DRB CASE ACTION LOG

DRB Application No.: 02-01535.

Project # 1002279

Project Name: COLEMAN ADDITION

**PLAT OF**  
**LOT 5-A & 5-B**  
**COLEMAN ADDITION**  
 SITUATE WITHIN SECTION 7,  
 T. 10 N., R. 3 E., N.M.P.M.  
 CITY OF ALBUQUERQUE  
 BERNALILLO COUNTY, NEW MEXICO  
 AUGUST 2002

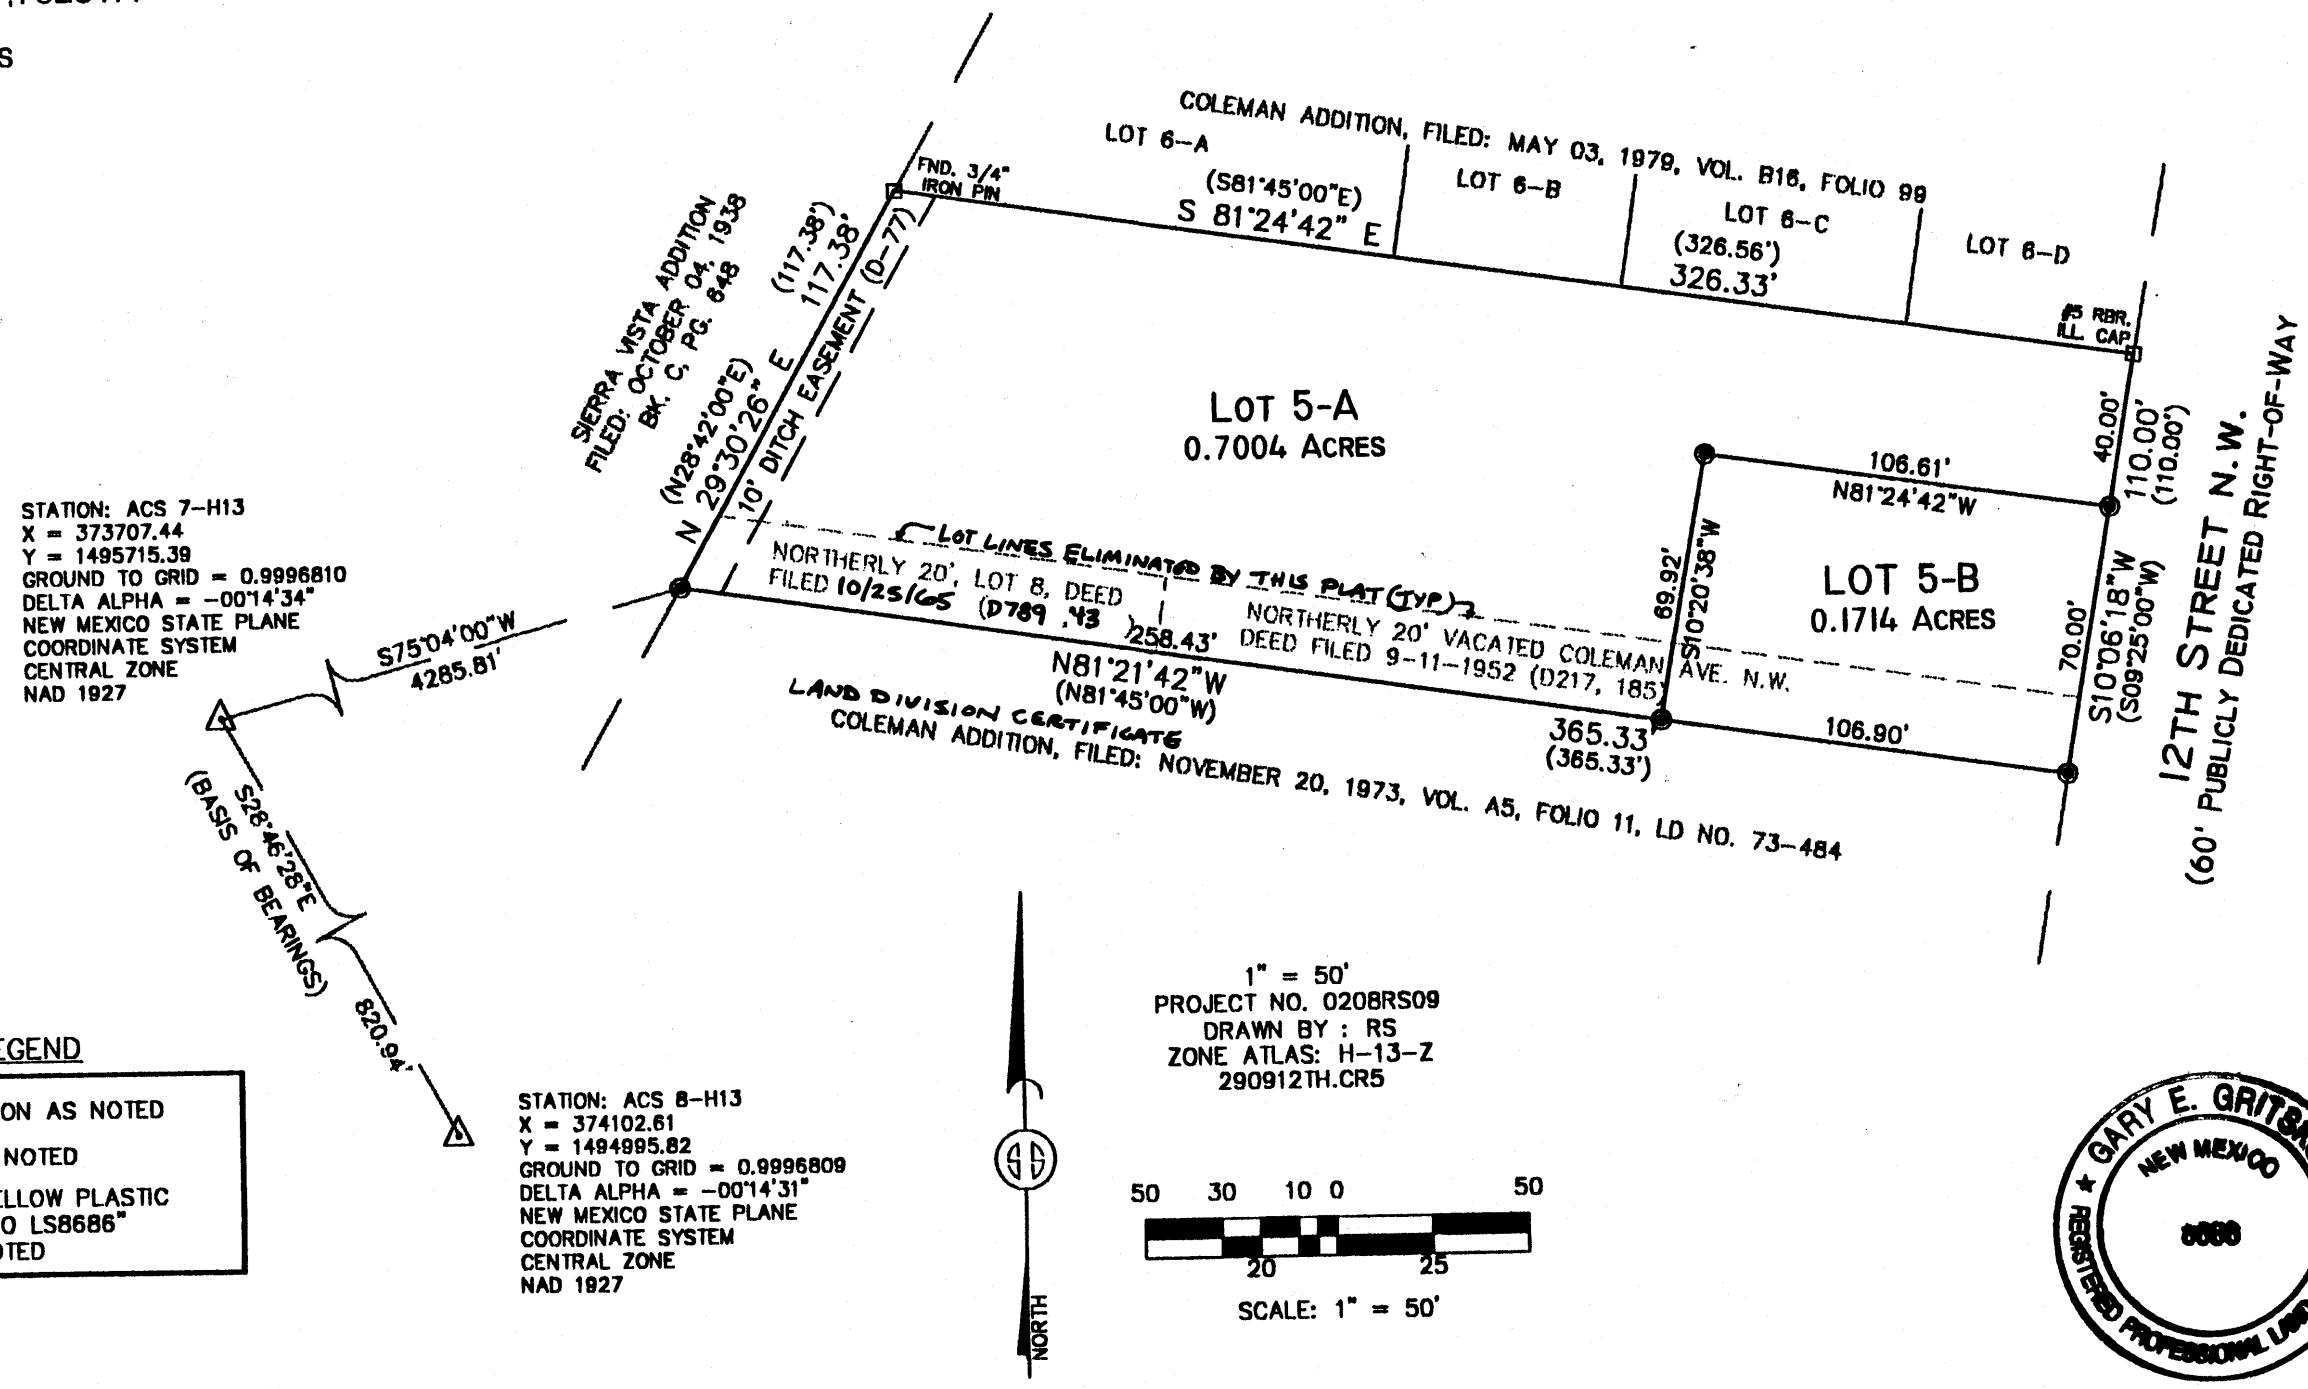
TRANSPORTATION: Check for 9' from face of curb to property line

No.	Comment
<input type="checkbox"/>	Does sidewalk, curb and gutter exist? If so, where with respect to the property line.
